CITY OF ALBUQUERQUE  
PLANNING DEPARTMENT  
DEVELOPMENT REVIEW BOARD

**10. Project # 1003779**

LARRY READ & ASSOCIATES INC agent(s) for ADIL RIZVI request(s) the above action(s) for all or a portion of Lot(s) 17 & 18, Block(s) 2, Tract(s) 2, NORTH ALBUQUERQUE ACRES, UNIT 3, (to be known as **KUMAIL SUBDIVISION**) zoned R-D, located on OAKLAND AVE NE, between WYOMING BLVD NE and LOUISIANA BLVD NE containing approximately 2 acre(s). [*Deferred from 12/8/04, 12/15/04 & 12/29/05*] (C-19)

## OFFICIAL NOTICE OF DECISION

PRELIMINARY PLAT OF KUMAIL SUBDIVISION
ALBUQUERQUE, BERNALILLO COUNTY, NEW MEXICO
A REPLAT OF LOTS 17 AND 18, BLOCK 2,
TRACT 2, UNIT 3, NORTH ALBUQUERQUE ACRES
WITHIN PROJECTED SECTION 21, T. 11 N., R. 4 E., NMPM
ELENA GALLEGOS GRANT
NOVEMBER 2004

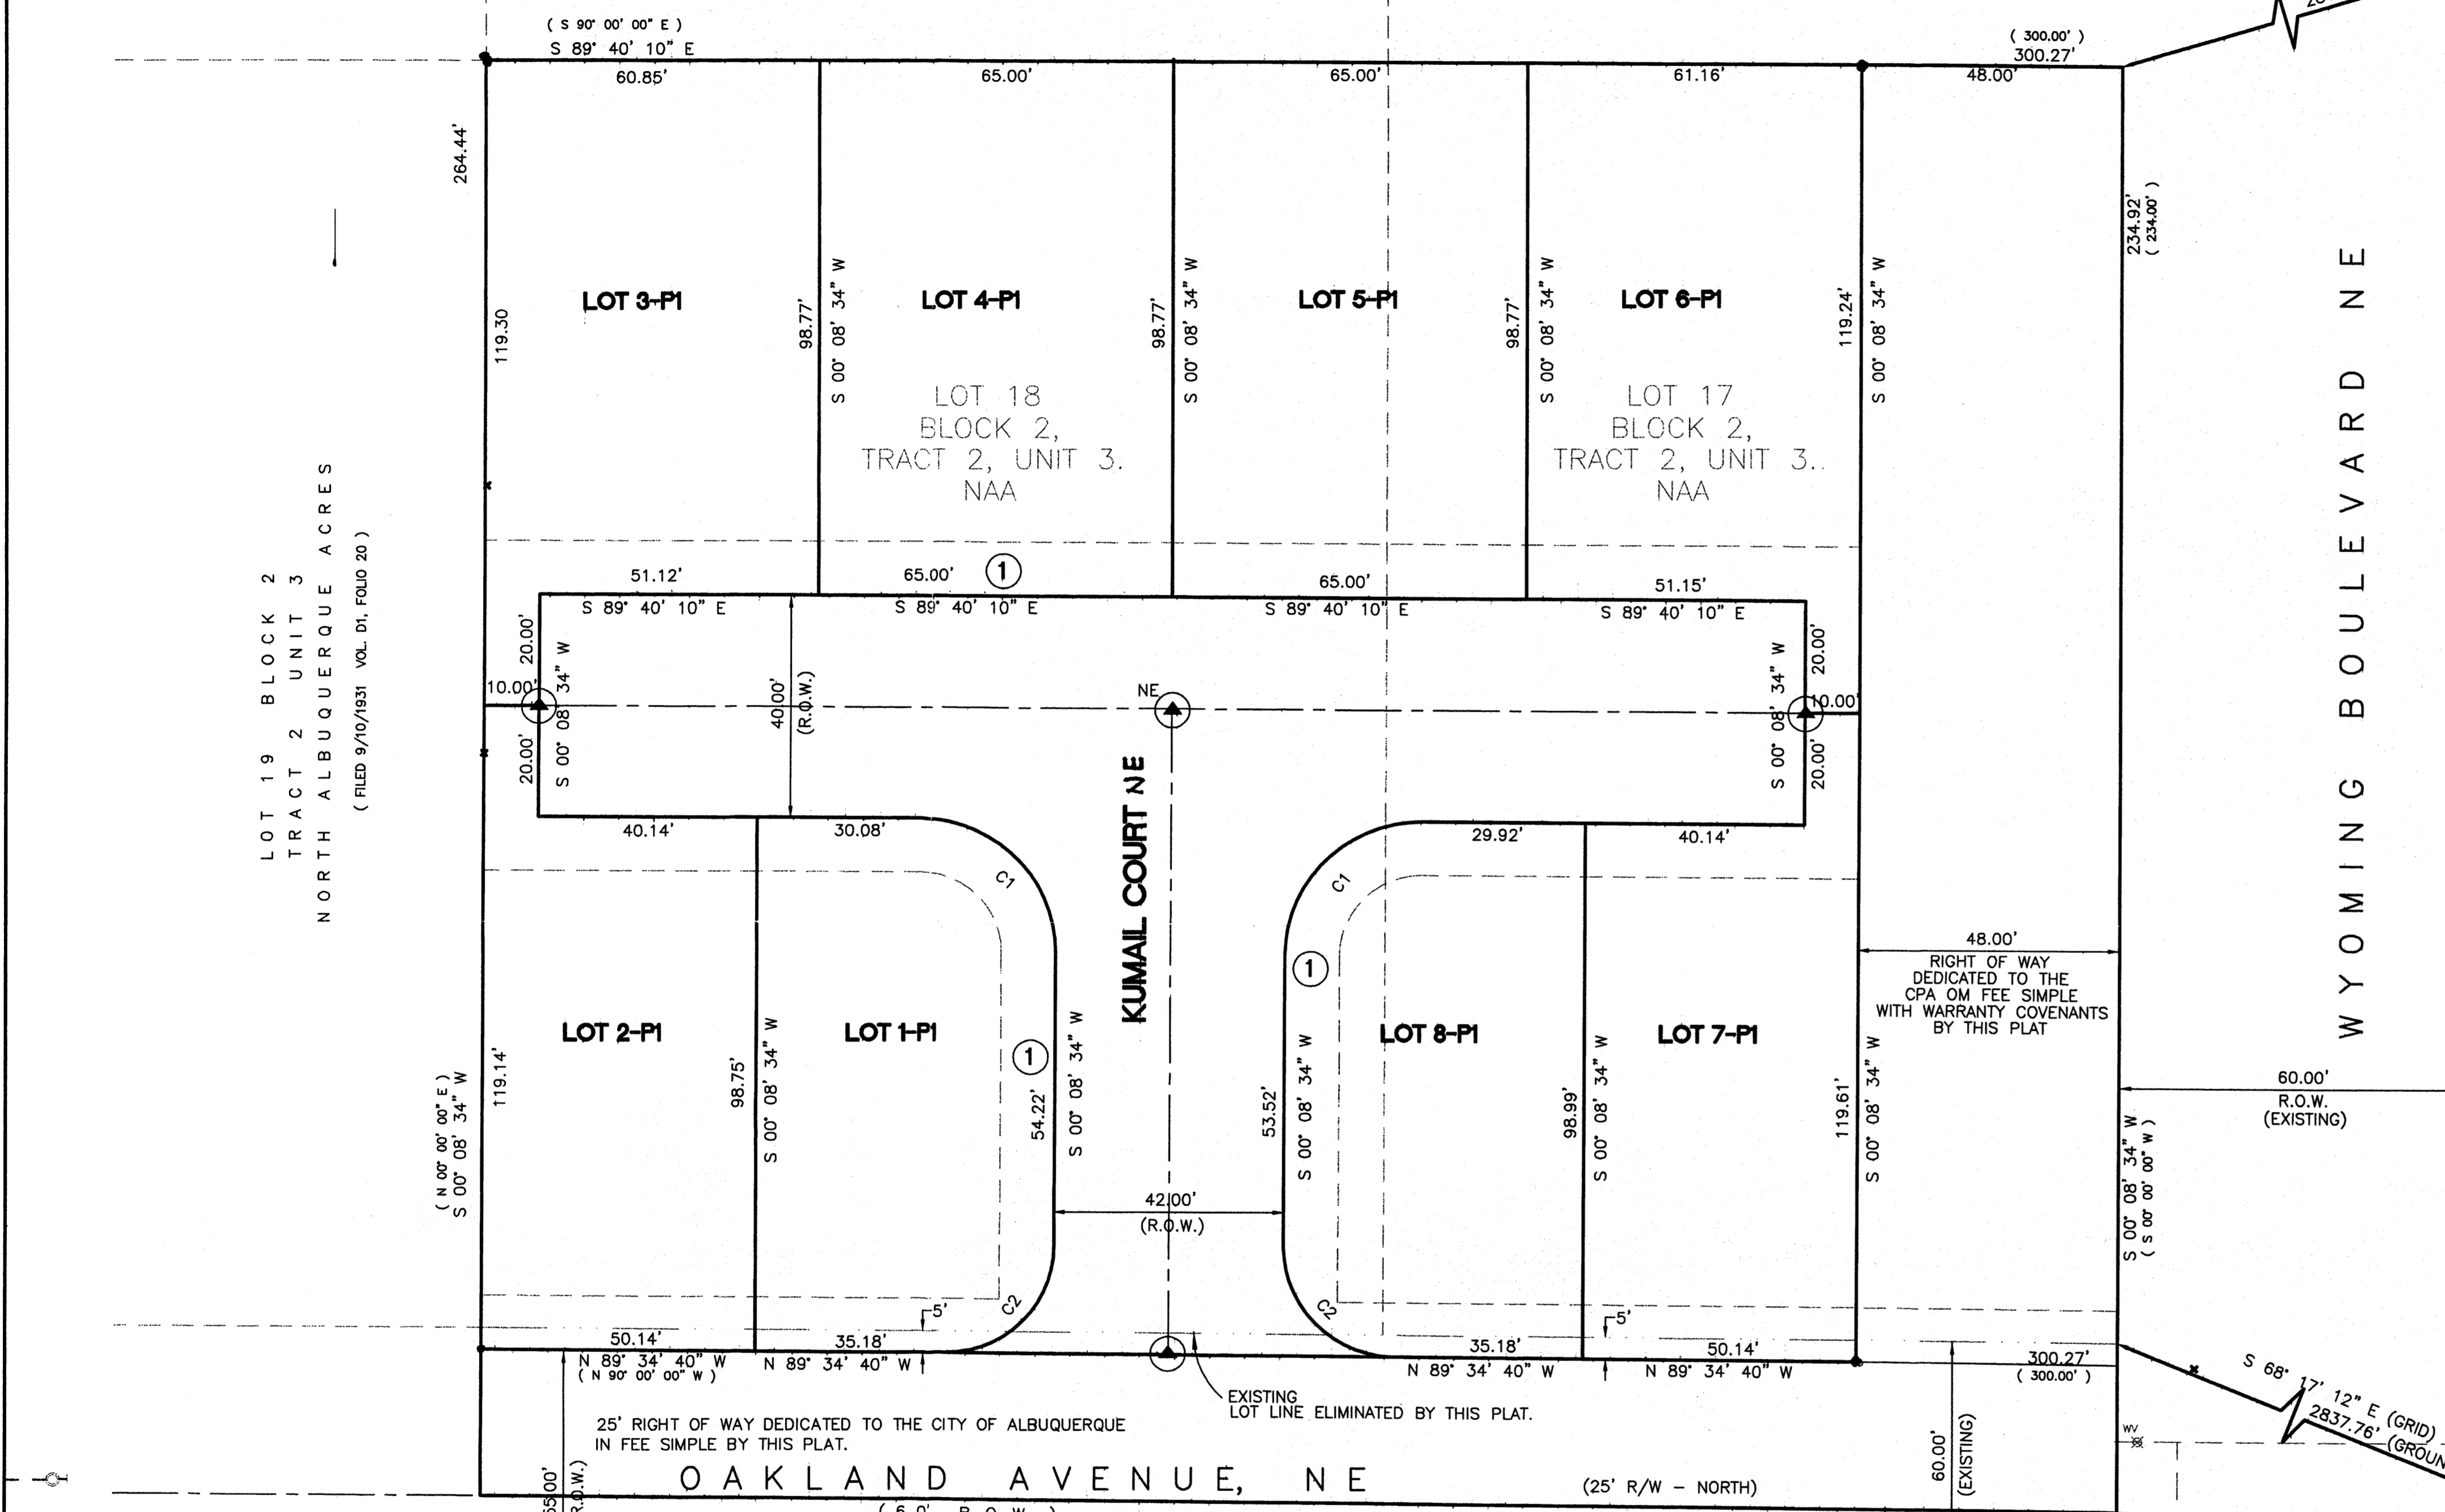
Street radius dedication shown at Lot 7.

PRELIMINARY PLAT OF KUMAIL SUBDIVISION
ALBUQUERQUE, BERNALILLO COUNTY, NEW MEXICO
A REPLAT OF LOTS 17 AND 18, BLOCK 2,
TRACT 2, UNIT 3, NORTH ALBUQUERQUE ACRES
WITHIN PROJECTED SECTION 21, T. 11 N., R. 4 E., NMPM
ELENA GALLEGOS GRANT
NOVEMBER 2004

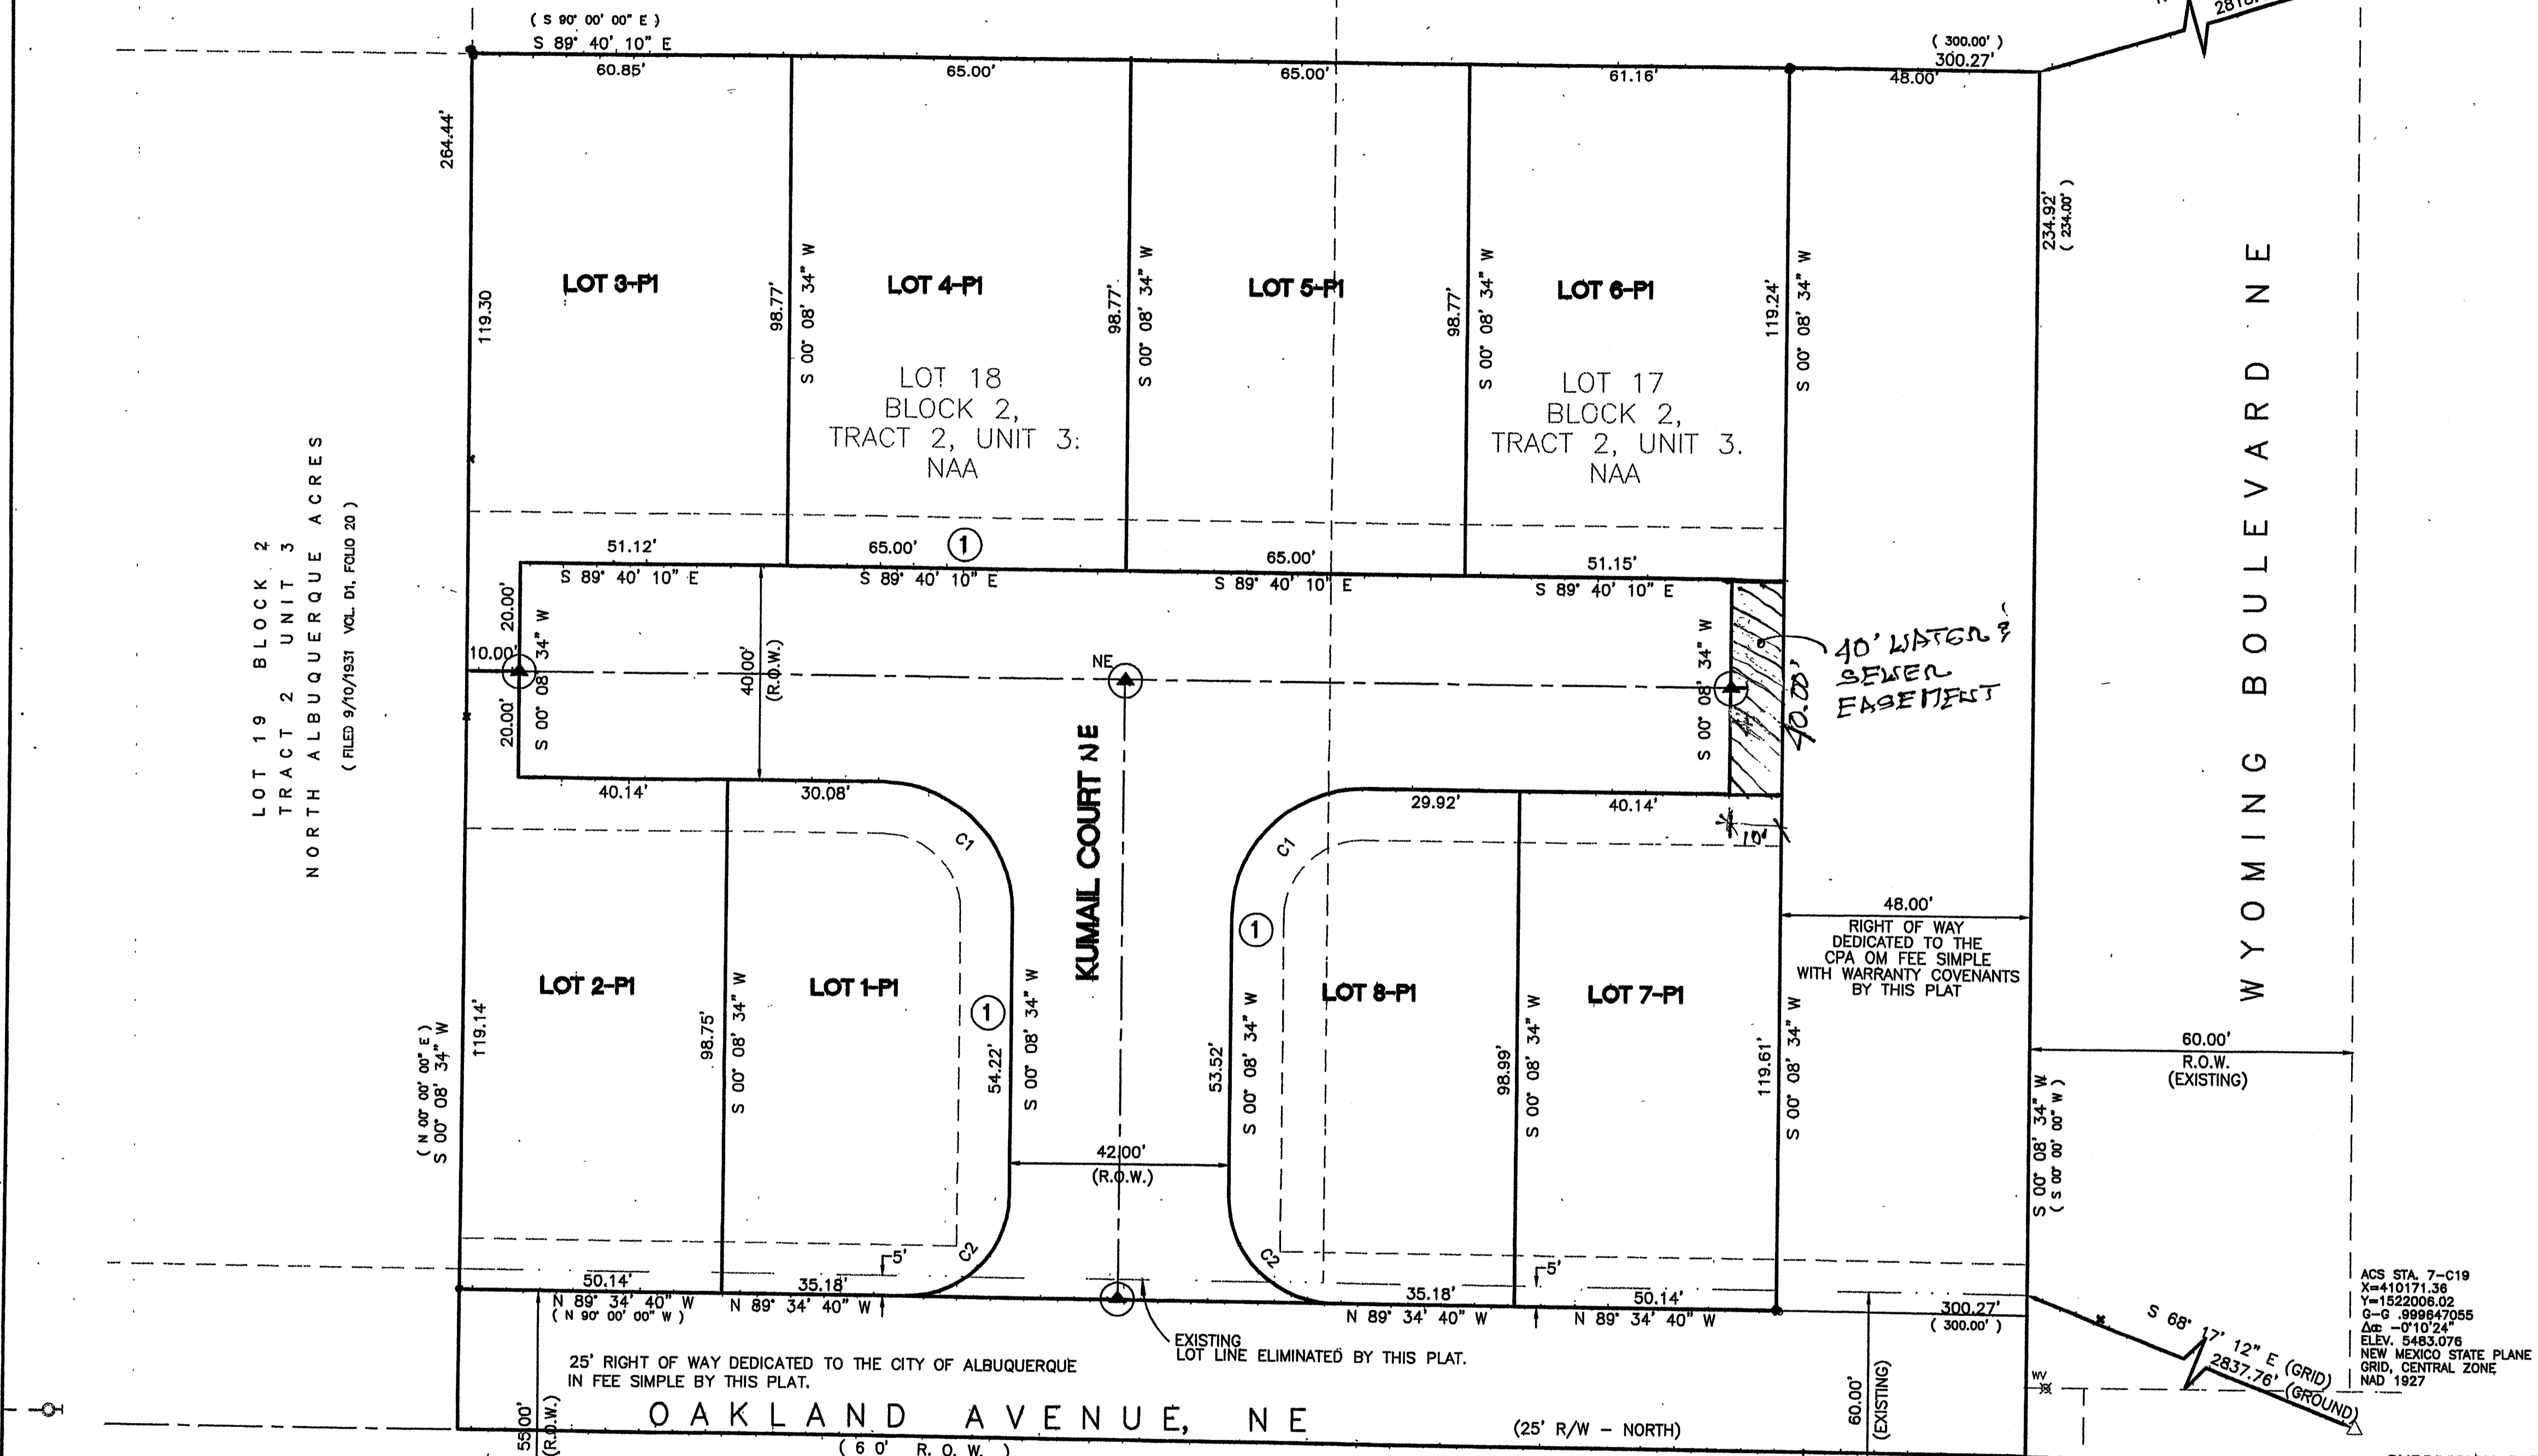
A radius dedication on Lot 7P1 is needed.
